**39 Oak Avenue
Ickenham
UB10 8LR**

PLANNING STATEMENT

Erection of a replacement dwellinghouse

SIDE ELEVATIONS (2/2)

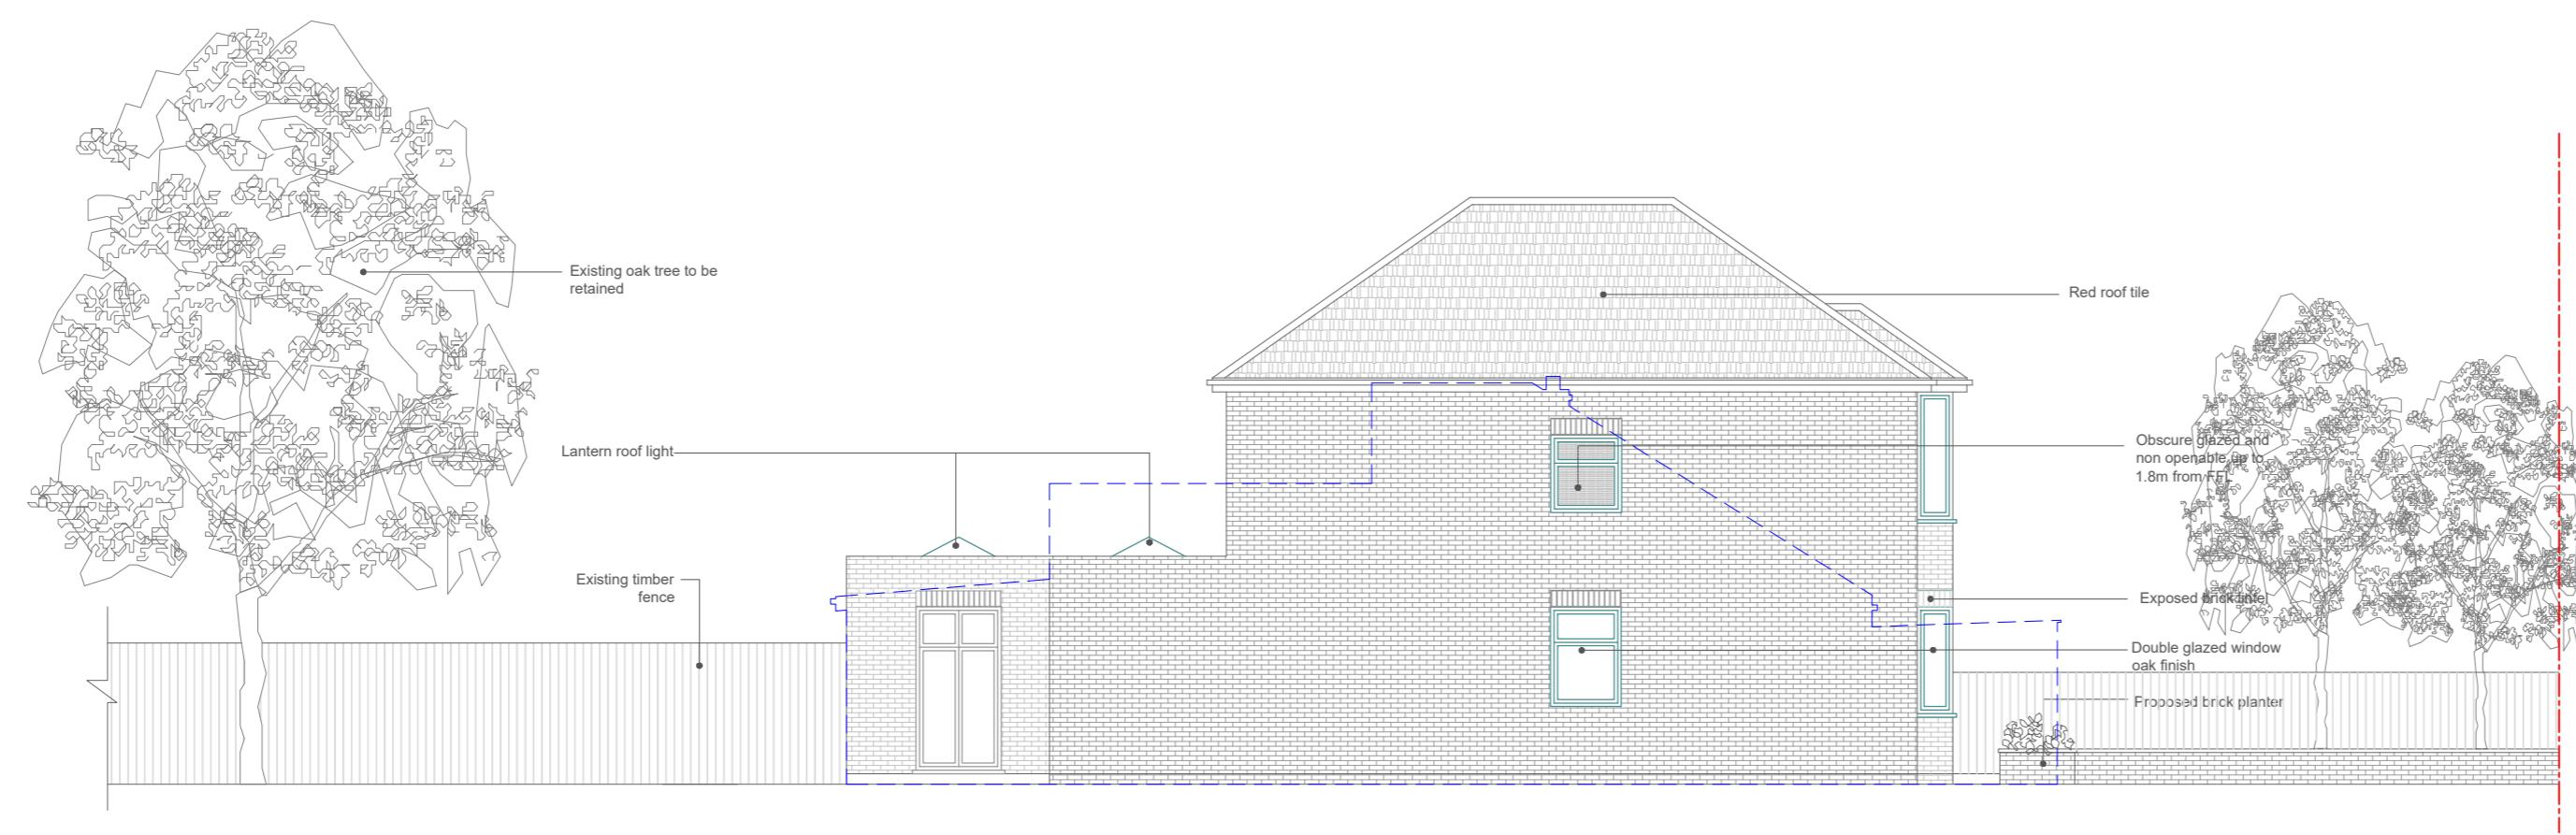
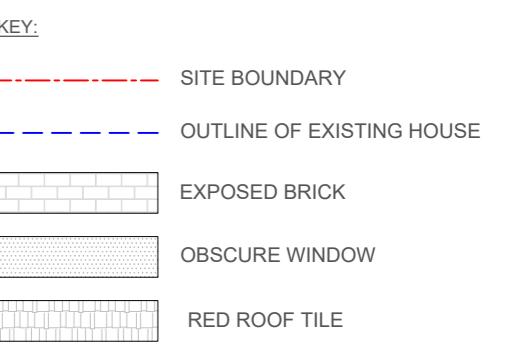
3.21 The final request from the planners in relation to residential amenity was that the side elevations demonstrate that the ground floor and first floor bathroom windows be obscure glazed and non-opening up to 1.8 metres above finished floor level and this annotation has now been added to the proposed drawings.
